SSD 6011 - Mixed use residential development within the South West Plot

Submission by:

Brett Baker

21 July 2013

Winter Solstice 3pm

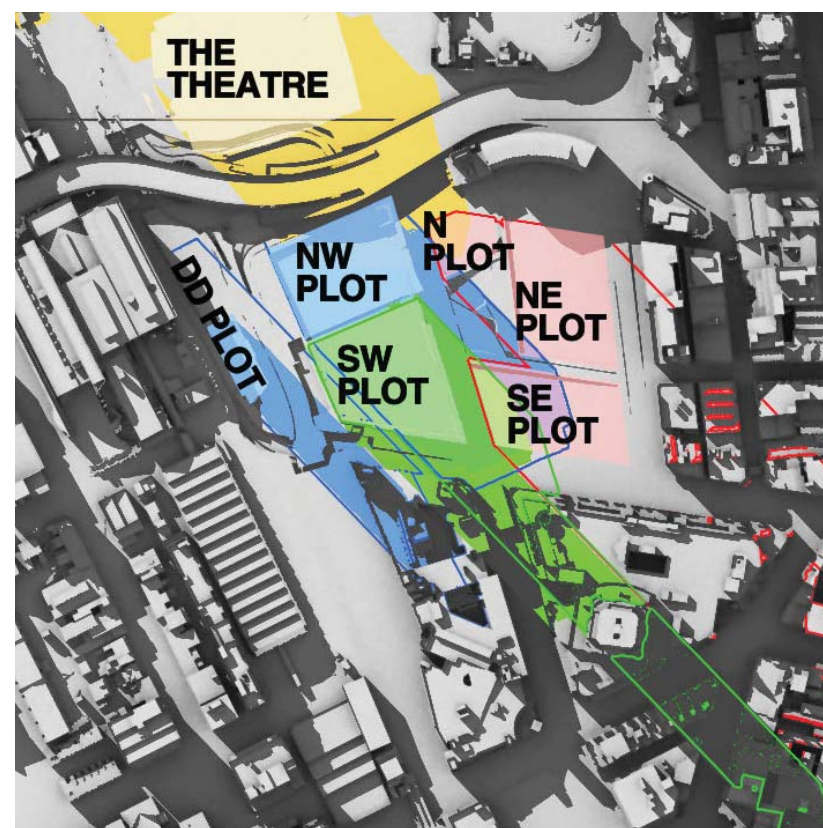
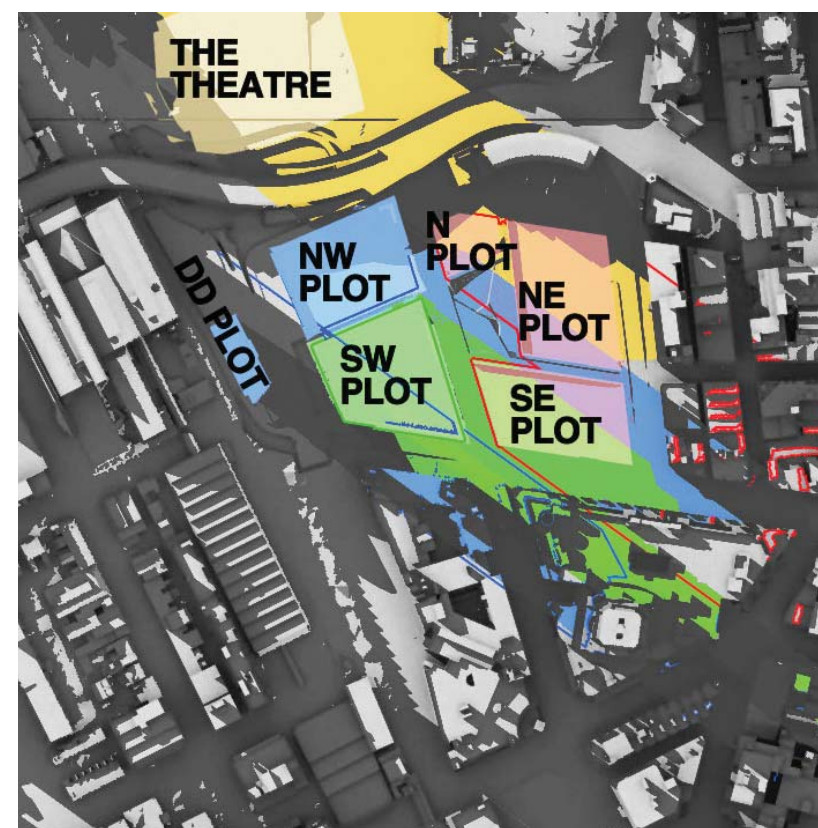
The proponent fails to take into account the existing shadowing of the west façade of The Peak.

The proponent provides diagrams but fails to discuss the existing shadowing of the west façade of The Peak.

At 9am, 10am and 11am the west façade is totally in shadow due to other parts of The Peak building itself.

At 12pm there is still substantial existing shadowing on the west façade caused by the irregular shape of the west facade.

At 1pm the existing shadowing has been substantially removed, but not totally removed.

It can be concluded that some single aspect apartments on the west façade and some south-west dual aspect corner apartments currently receive less than 2 hours direct sunlight to habitable rooms and 50% of the private open space between 9am and 3pm on 21 June.

By 2pm the existing shadowing has been totally removed, but that is too late to achieve two hours of direct sunlight before 3pm.

At 1pm the existing shadowing has been substantially, although not entirely, removed. However, overshadowing of lower levels of the west façade by the concept proposal parameter plan shadows for the N,NE and SE plots has already started.

By 2pm the existing shadowing has been totally removed. However, overshadowing of the west façade by the SSDA4 and SSDA5 buildings has appeared and risen further up the west façade than the concept proposal parameter plan shadows for the N,NE and SE plots, which is still present.

At 3pm, the proponent states correctly that 45-45% of the western façade is overshadowed by the SSDA4 and SSDA5 buildings.

It can be concluded that, as a result of combination of the proposed development with existing shadowing of the west façade, some single aspect apartments on the west façade and the south-west dual aspect corner apartments which currently receive less than 2 hours direct sunlight to habitable rooms and 50% of the private open space between 9am and 3pm on 21 June will suffer additional overshadowing. It is beyond our skills to count the number of such apartments. We note that the proponent has made no attempt to do so.

Rather than counting the number of units which will not meet the DCP guidelines, the proponent attempts to trade-off direct sunlight at 4pm for lack of direct sunlight during the period 9am to 3pm. There is no provision in the DCP guidelines for such a trade-off.
